PROJECT NAME: CSP SCAREBROOK  
EXISTING 68'-0" MONOPINE  
(OVERALL HEIGHT: 73'-0" A.G.L.)  
COLLOCATION COMMUNICATION SITE

SHEET TITLE:  
ELEVATION

SAVE DATE: 8/28/2018 9:03 AM  
SHEET NUMBER: Z3

# Markup Summary

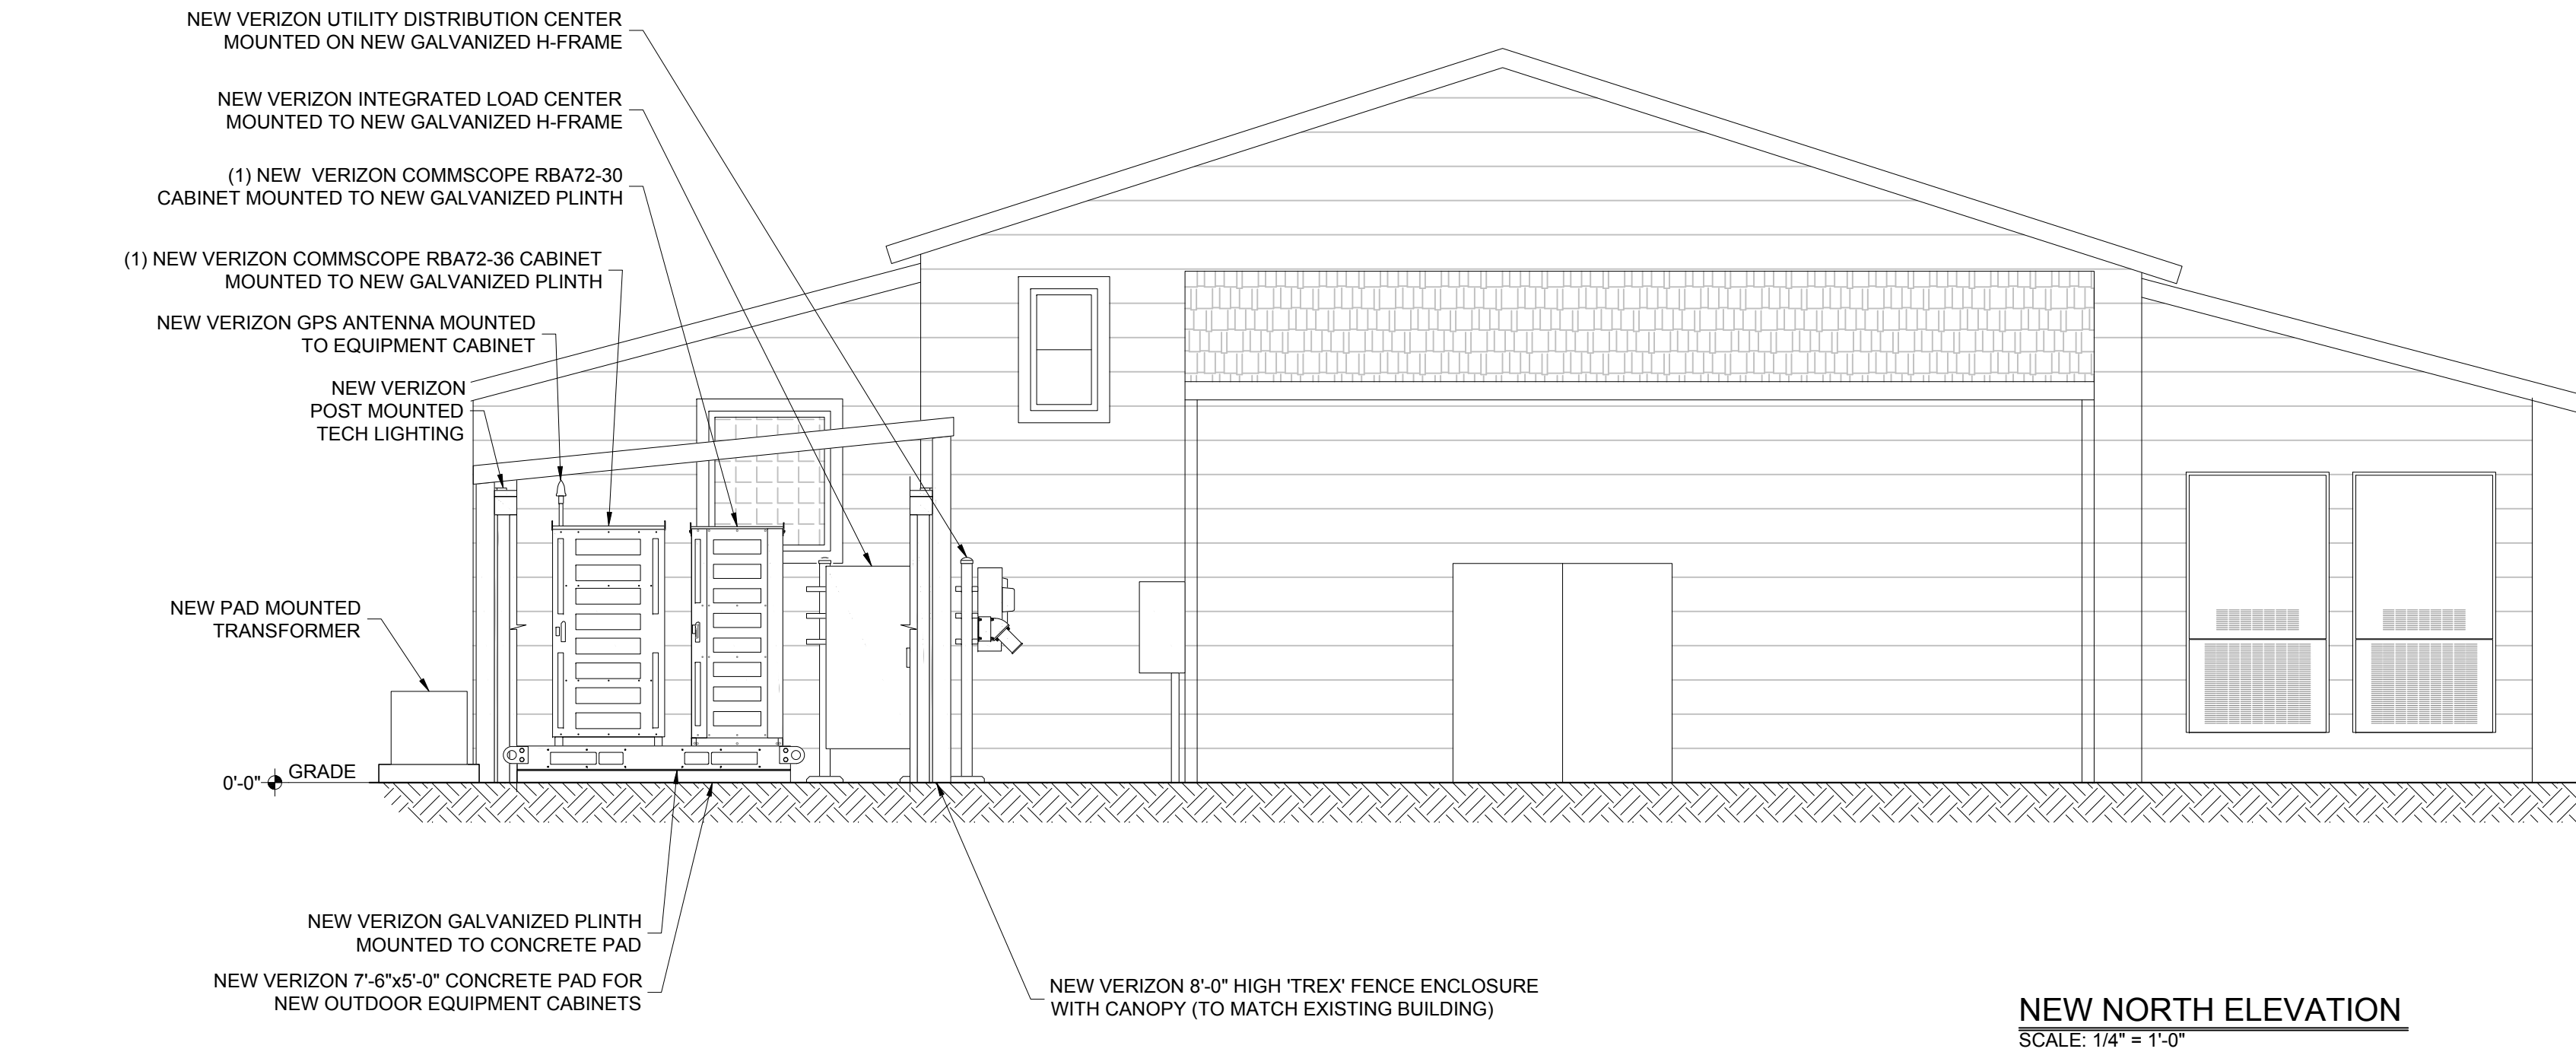
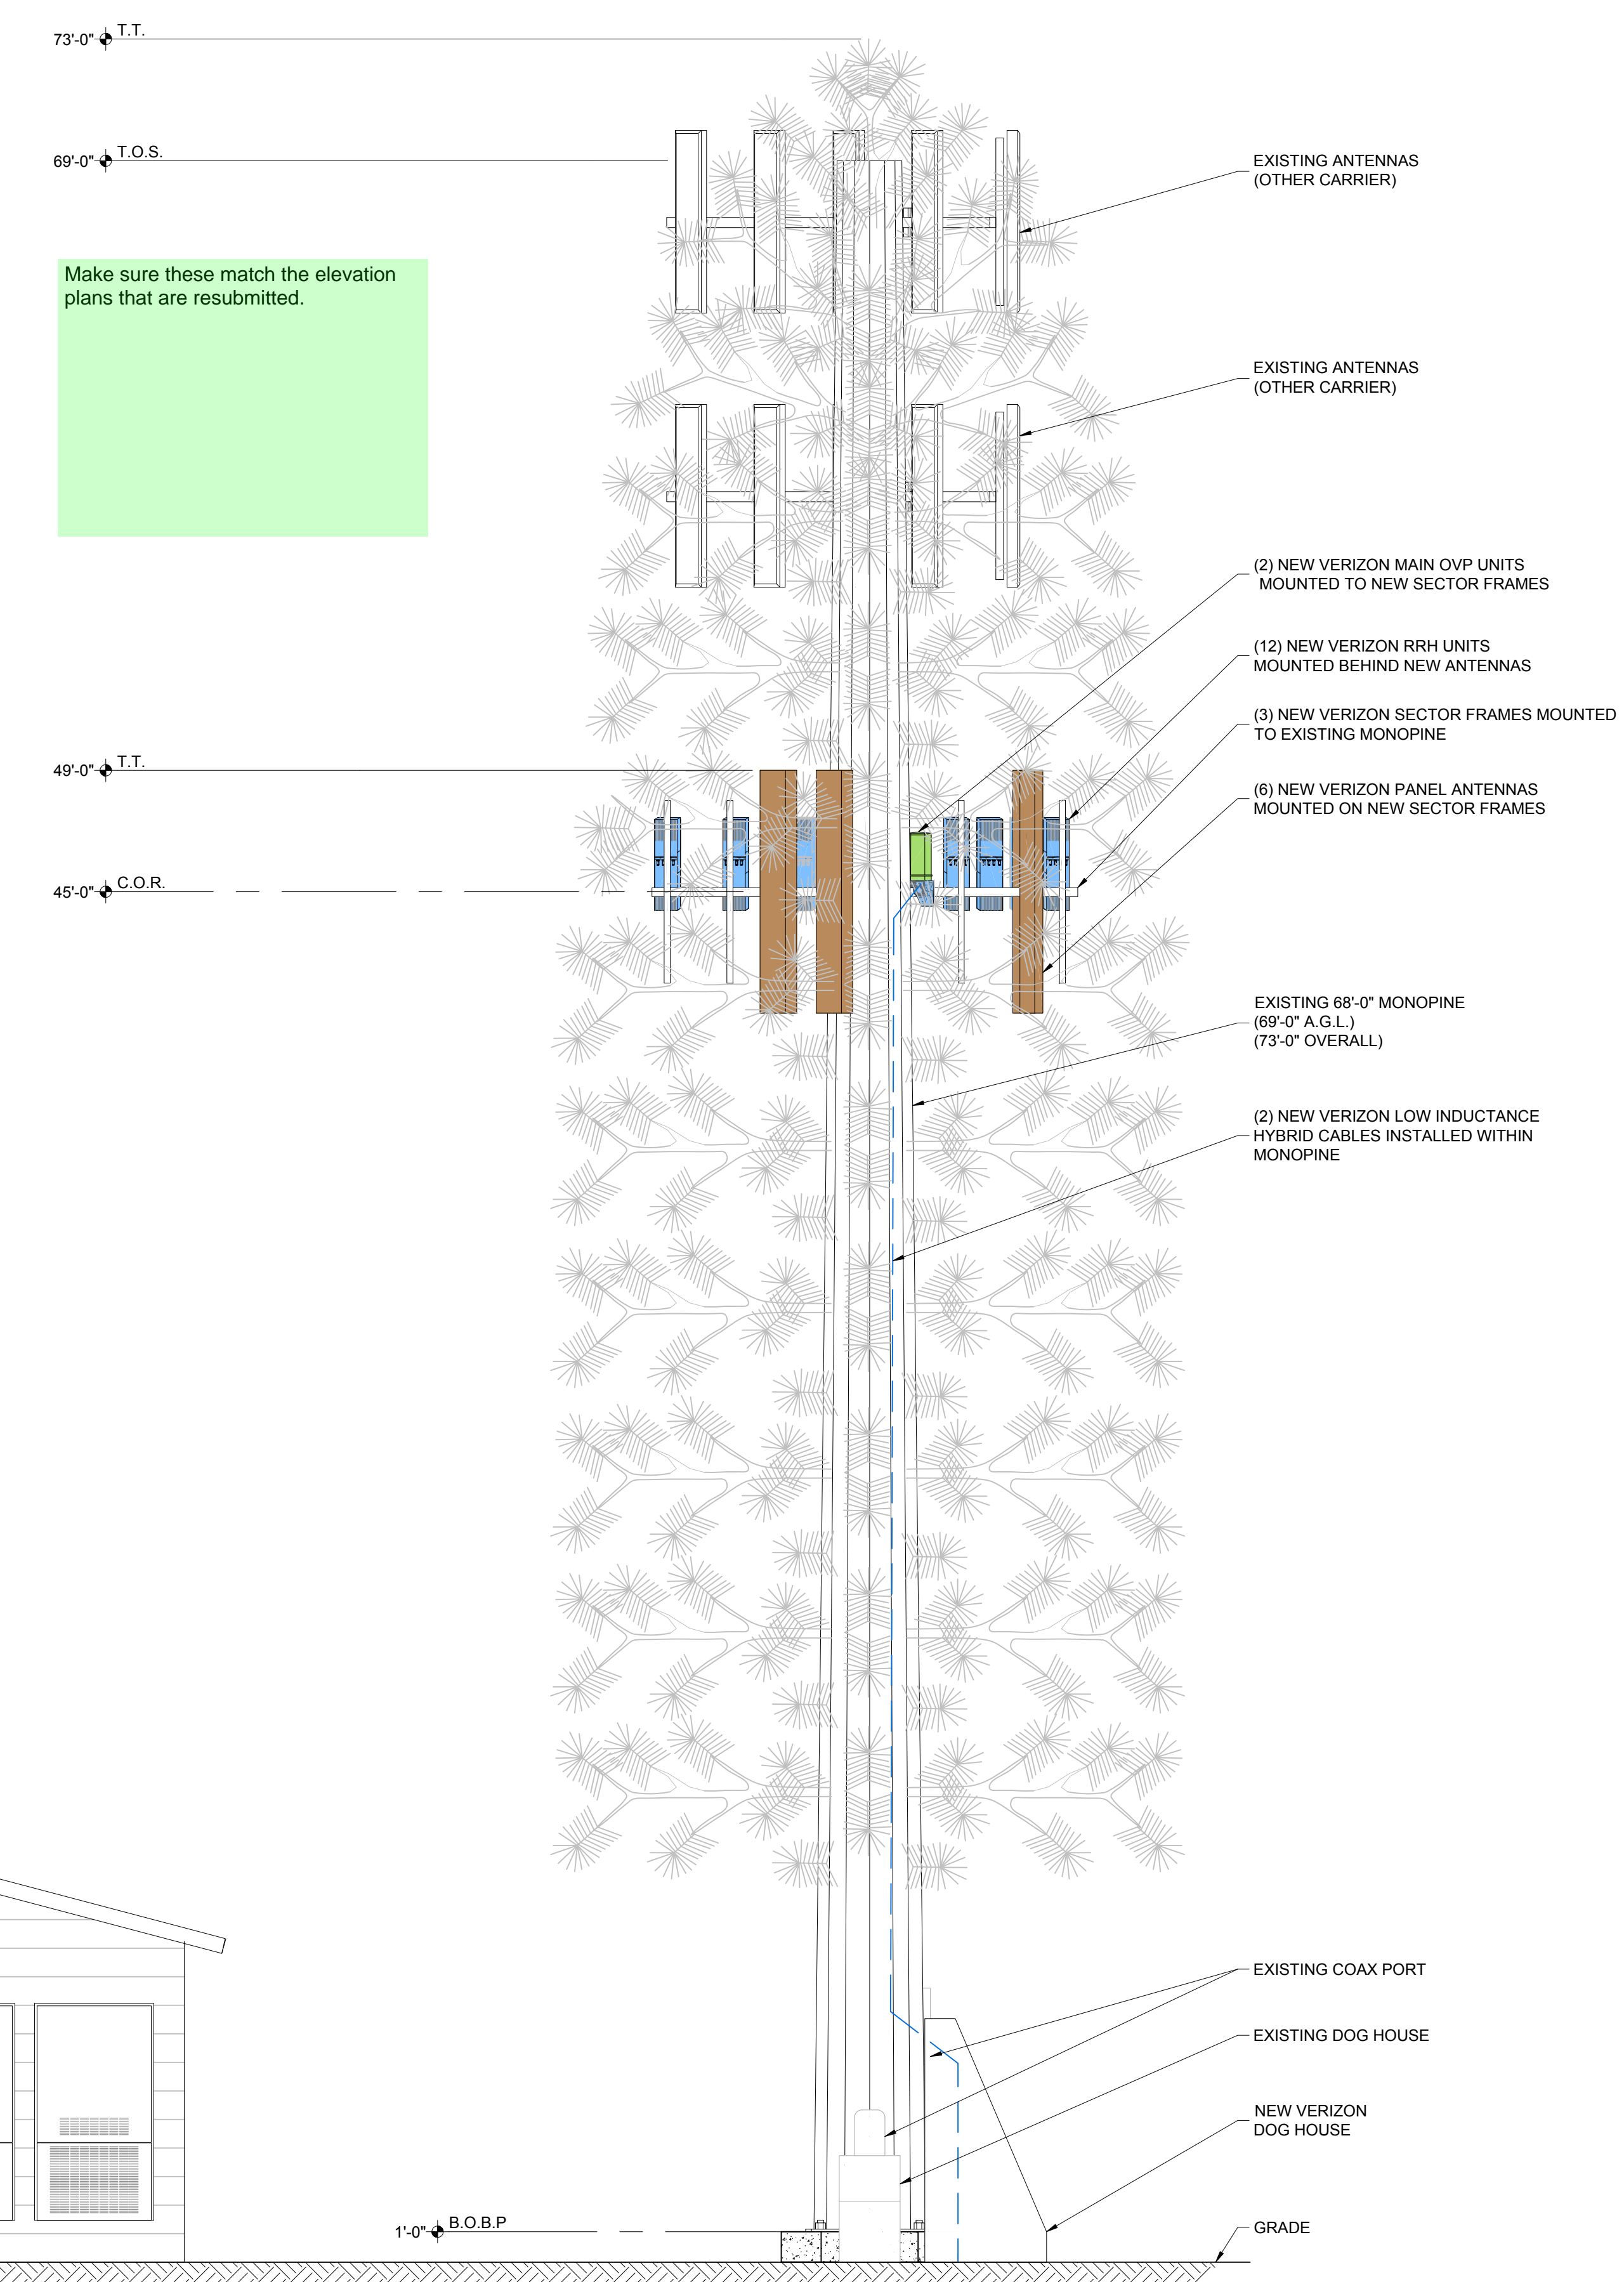
Is this stealth or non-stealth as stated on record in the resolutions of va122.  
Are the branches existing?  
Show the top of the antennae at 70' not the middle at 69'.
